From: Sarah Burrow <Sarah.Burrow@arun.gov.uk>
Sent: 08 September 2022 10:22
To: Planning.Responses <Planning.Responses@arun.gov.uk>
Cc: Simon Davis <Simon.Davis@arun.gov.uk>; Paul Cann <Paul.Cann@arun.gov.uk>
Subject: RE: Planning Consultation on: AL/49/22/PL

Application No: AL/49/22/PL

Site Address: Sussex Recovery Company Fontwell Avenue Eastergate PO20 3RU

Description of Works: Demolition of all existing buildings and structures and redevelopment of the existing car salvage and recycling facility to provide 80 No dwellings and a co-working hub, with vehicular access from Fontwell Avenue, provision of public open space, landscaping, and other associated works. This application is a Departure from the Development Plan is in CIL Zone 3 and is CIL Liable as new dwellings.

TYPICAL SECTION THROUGH PERMEABLE PAVING & SOAKAWAY

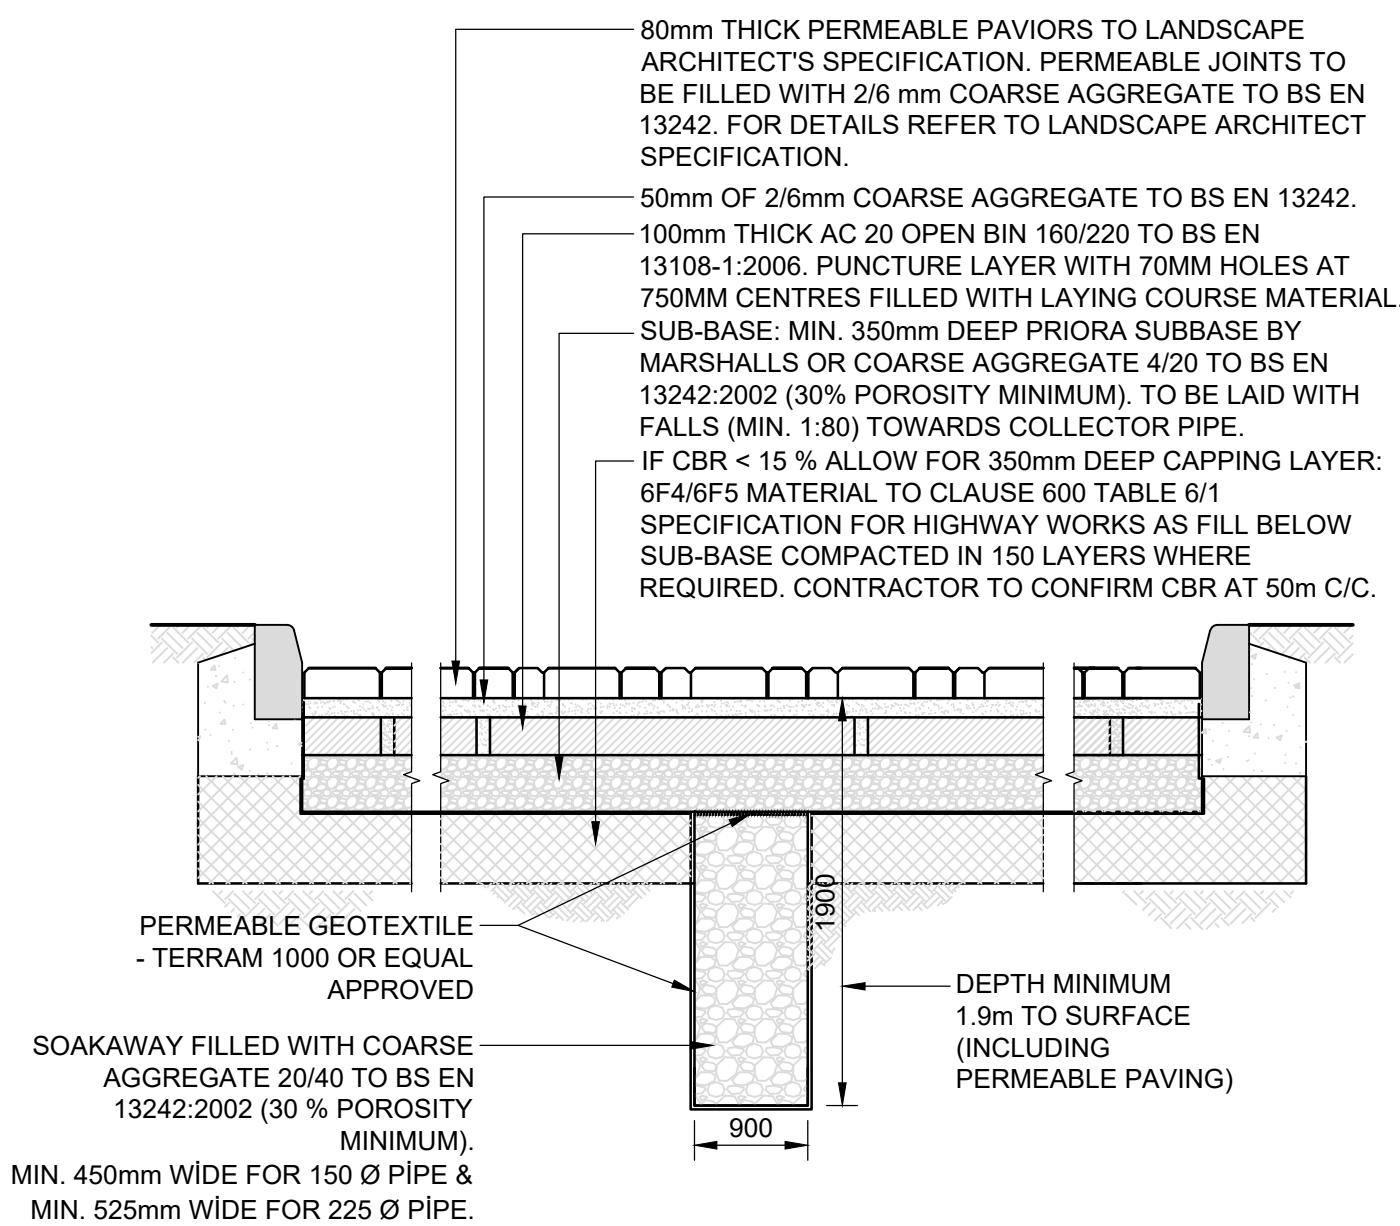
- 3) A justification for why base infiltration has been applied to some of the drainage features should be provided. Base infiltration should only be applied to infiltration drainage features where base infiltration is a significant contributing factor, e.g. infiltration blankets, or permeable paving, and should not be applied to soakaways.

HOUSE SOAKAWAY PLAN DETAIL

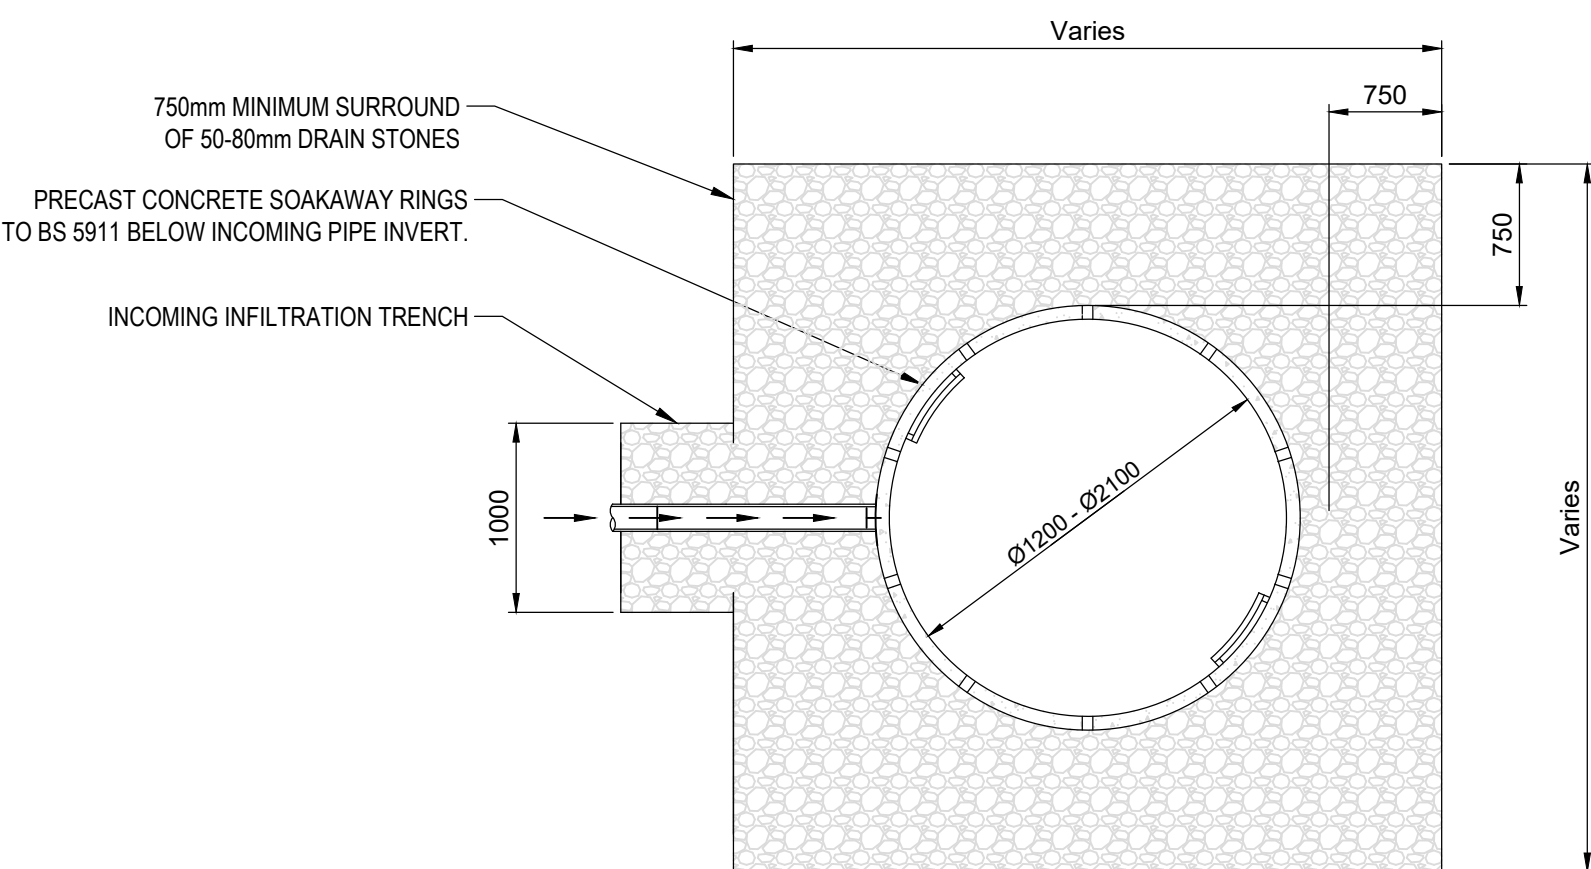
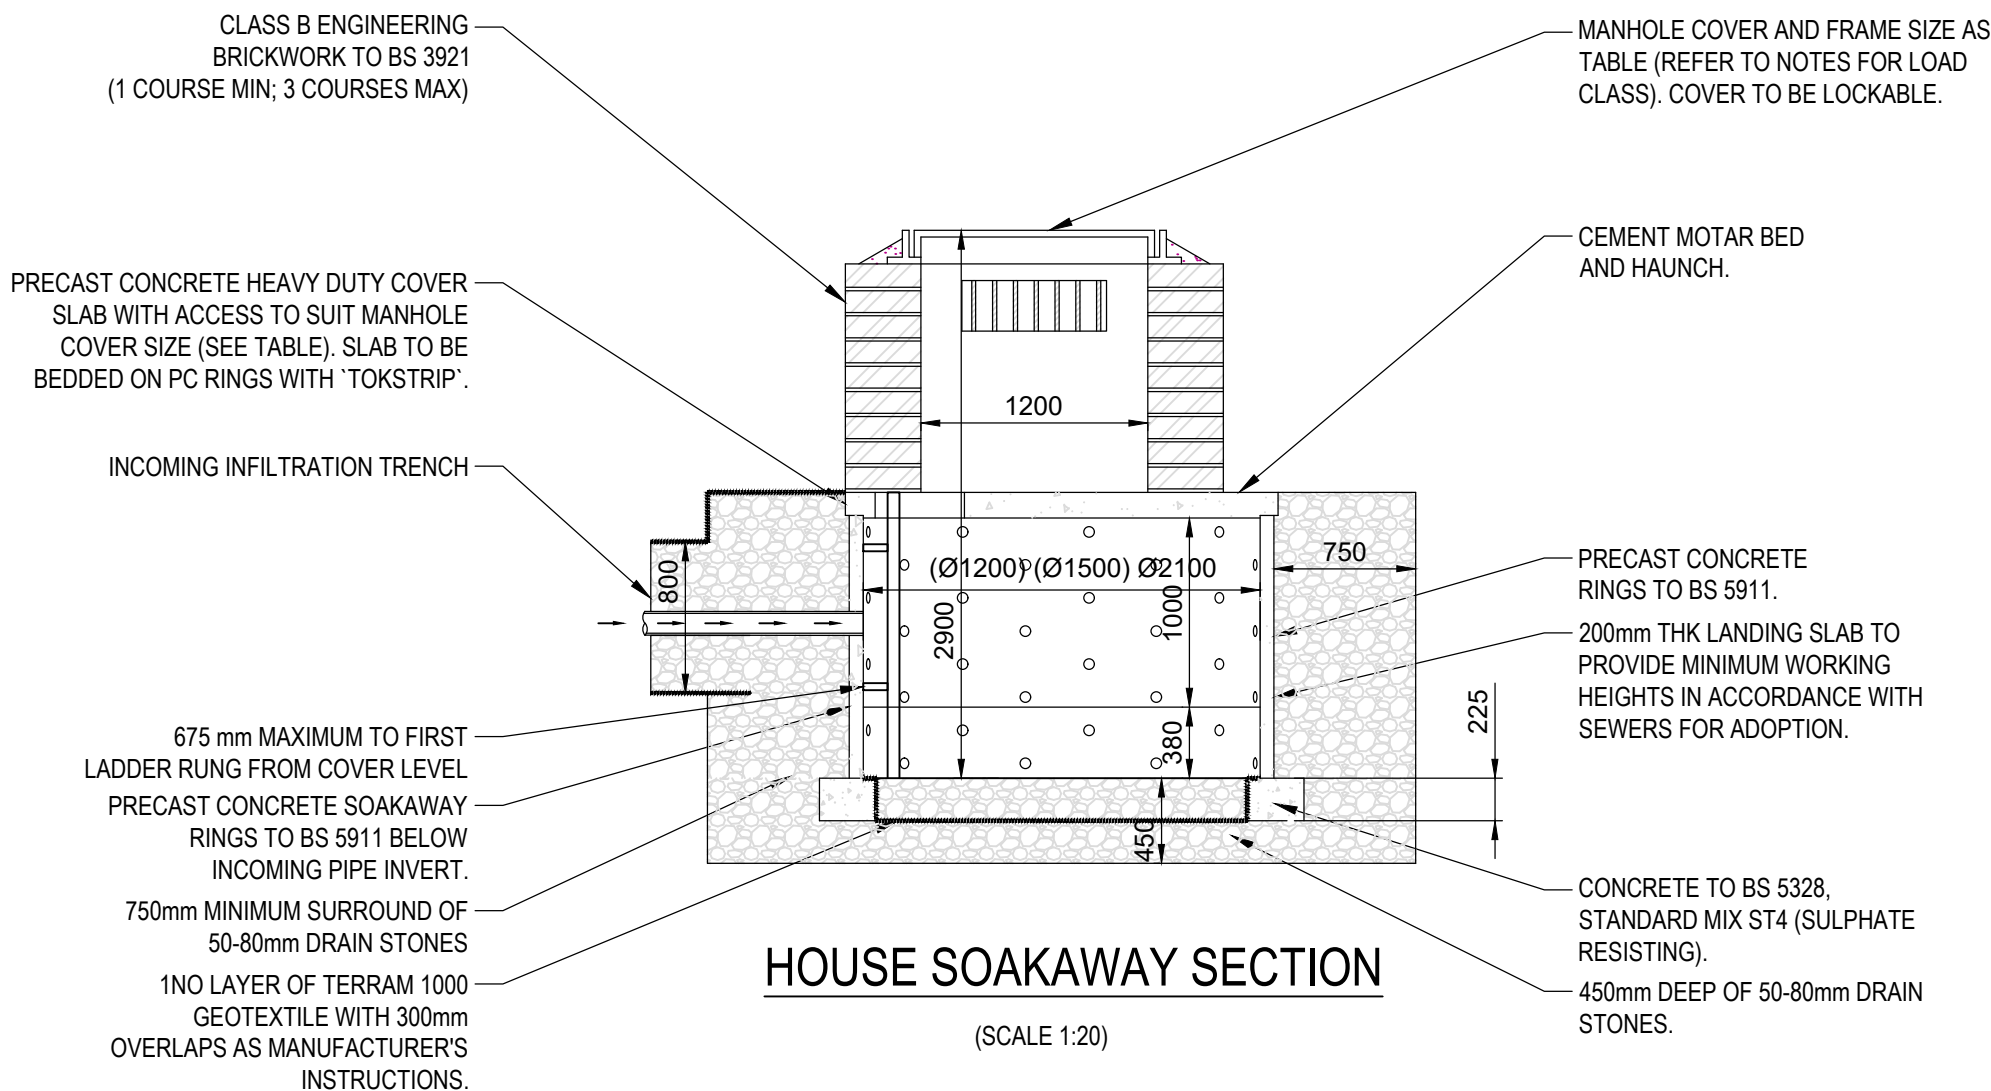
- 2) Many of the proposed soakaways are in close proximity to other soakaways. The effects of interference between soakaways located near to each other should be considered within the drainage calculations, e.g. if any soakaways are located within 10m of another infiltration feature.

- 5) Pollution control section 5.8.3 states achieved, calculations for this are included in appendix F and include indices for filter drains / soakaways. We note that reliance on house soakaways to provide treatment may require design changes from a ring / house soakaway design, due to the associated indices requiring (paraphrased from table 26.4 C753) a suitable depth of filtration material, i.e. gravel with sufficient smaller particles but not single sized coarse aggregate. The applicant should confirm that there is sufficient flexibility in the design to allow a smaller graded aggregate to be used if the soakaways are providing treatment and design requires it.

- 6) We request that the gravel surround for any of the ring soakaways should be shown on the drainage layout plan, this is to ensure the surround does not conflict with any other features specified within the scheme design, or come within 5m of any building.
